APPLICATION **LY/15/18/DOC**
NO:

Registered: 24-JUL-18
Site Address: Crossbush Farm Shop Lyminster Road Lyminster BN17 7QN

Description of Works: Approval of details reserved by condition imposed under LY/28/17/PL relating to conditions 5-equipment to control odour/fumes, 9-secured & covered cycle parking & 11- closing of Calceto Lane for egress of vehicles.

A

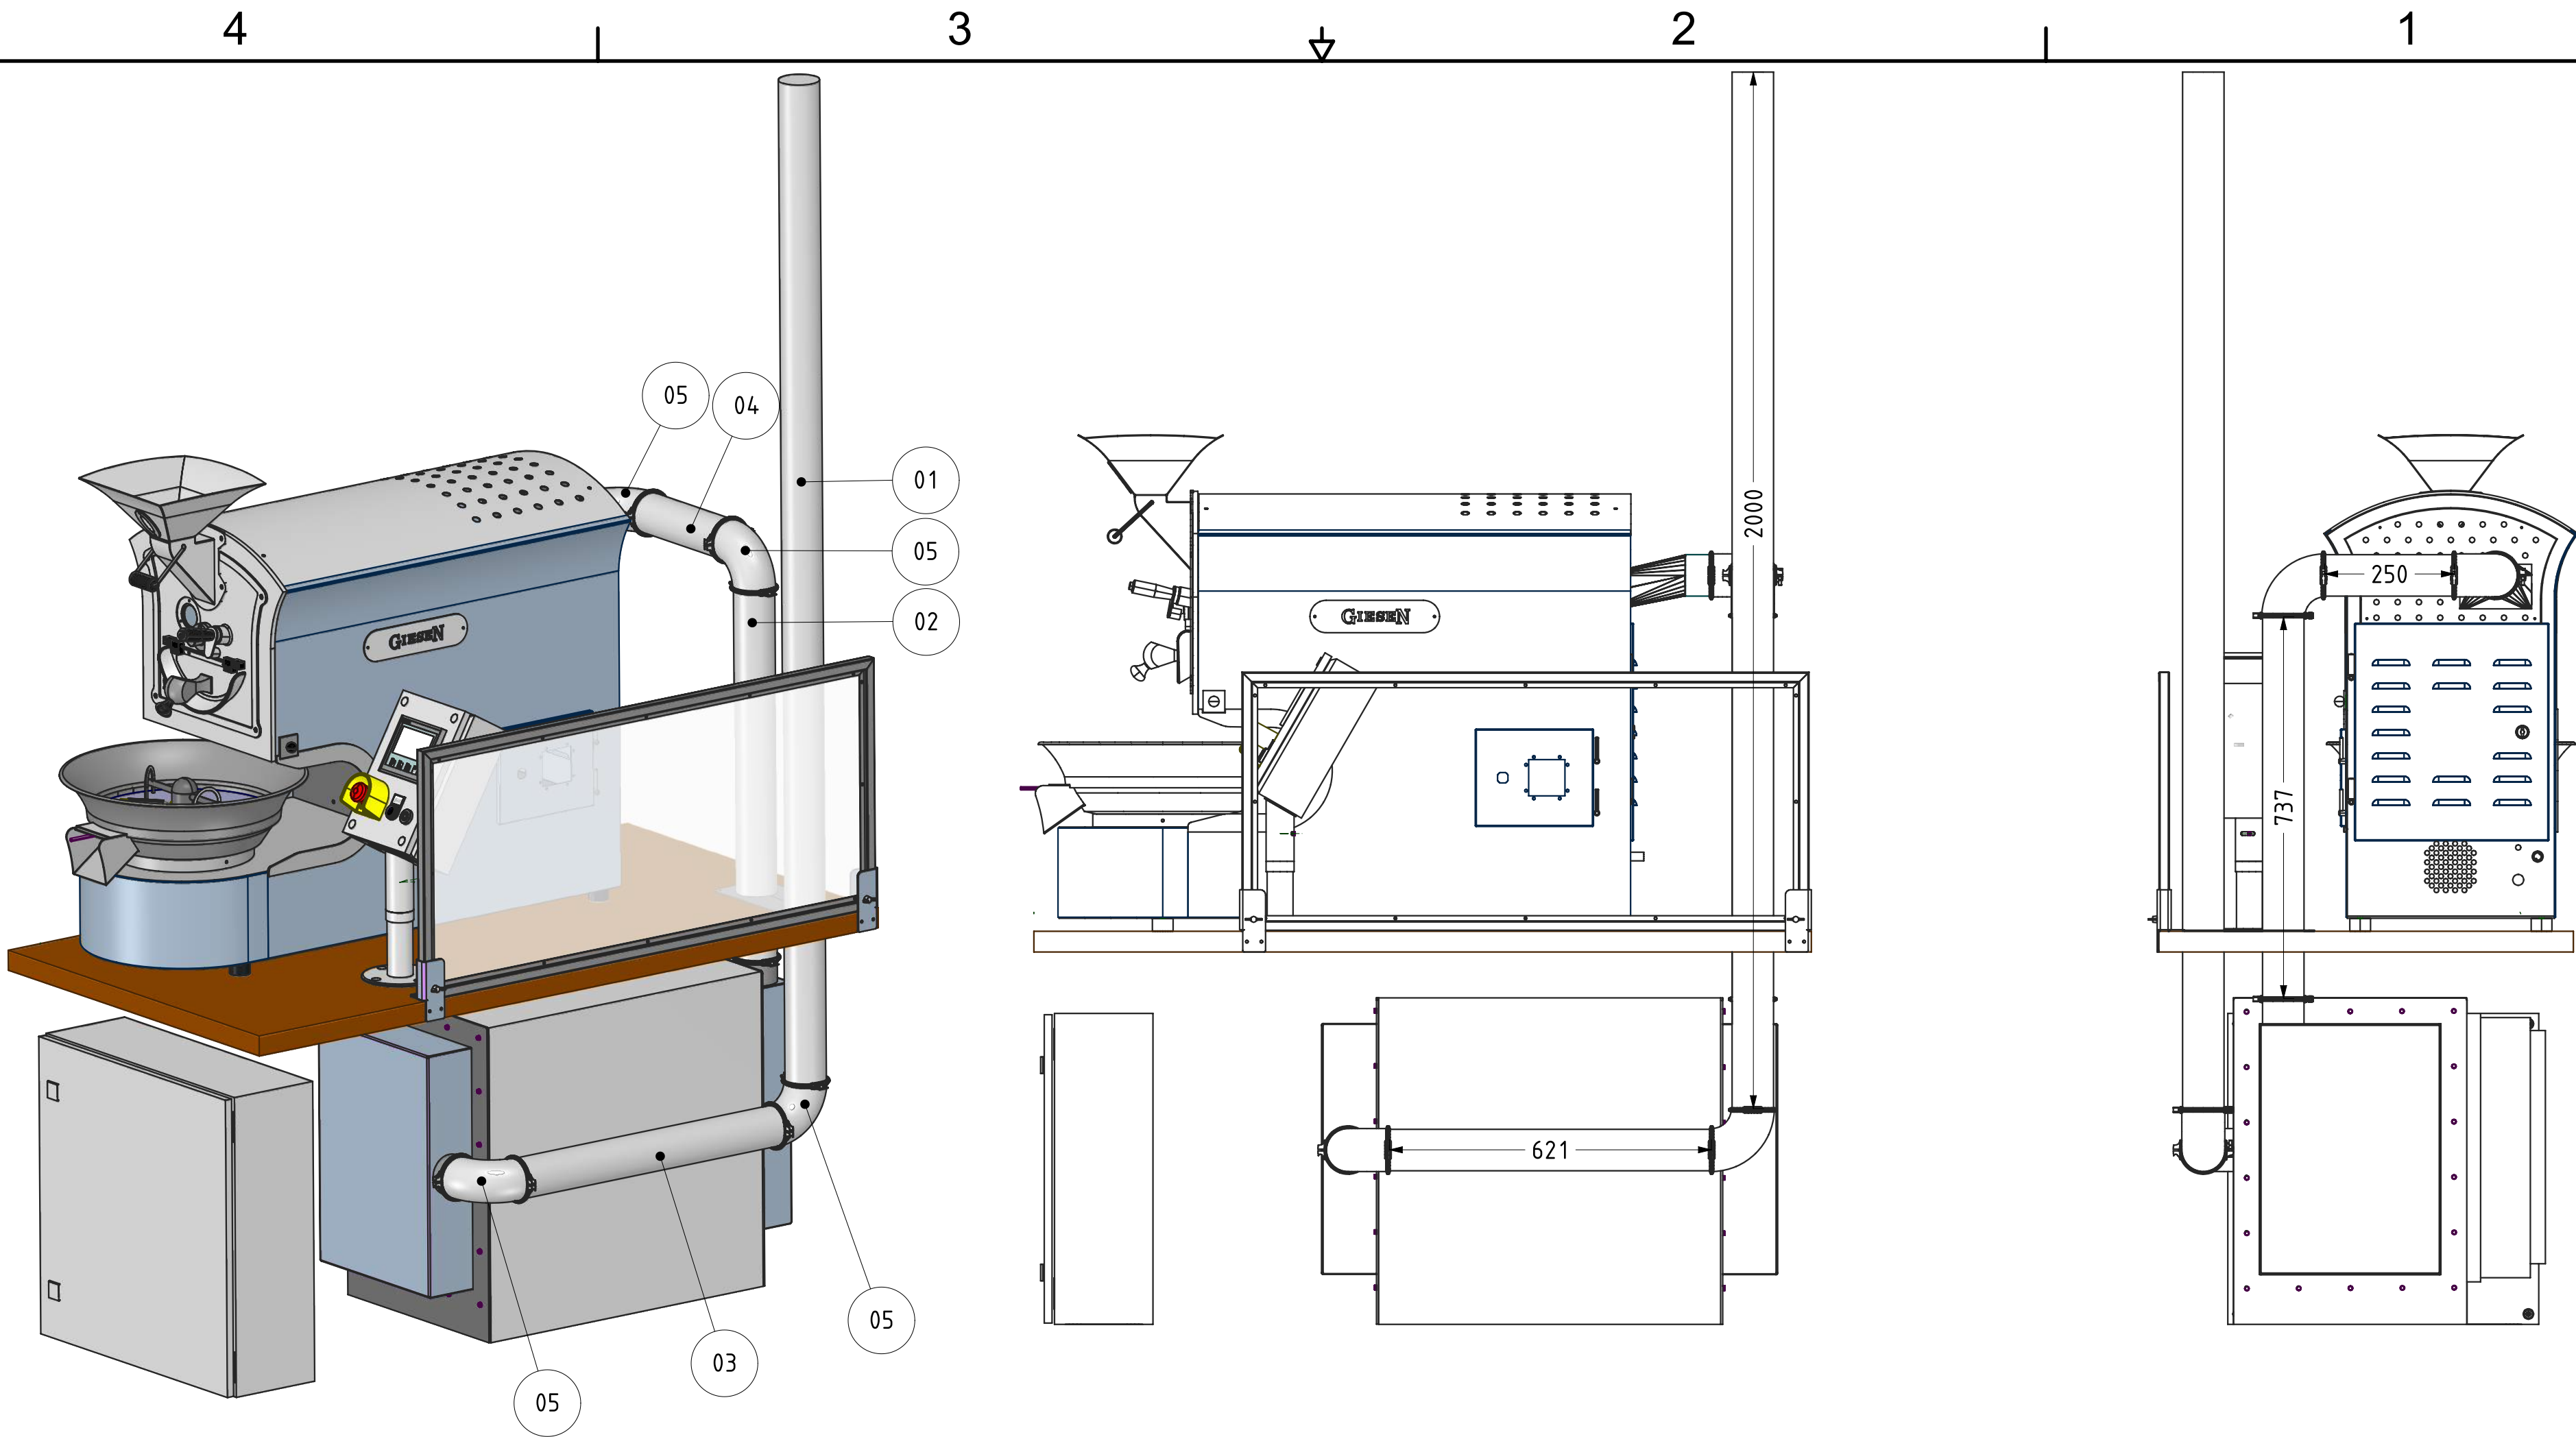
Environmental Health: Agree to discharge of condition 5 in respect of control of odour/fume. This is based on the stated provision of Geisson coffee roaster (which produces no odour) and odour abatement equipment comprising essentially 1 x 1MXB2 Maxicarb unit with retention time of not less than 0.3 seconds(or equivalent) and associated fan both to be fitted inside the building. The flue exit to be above eaves level and provided with a rotating cowl to maximise dispersion.
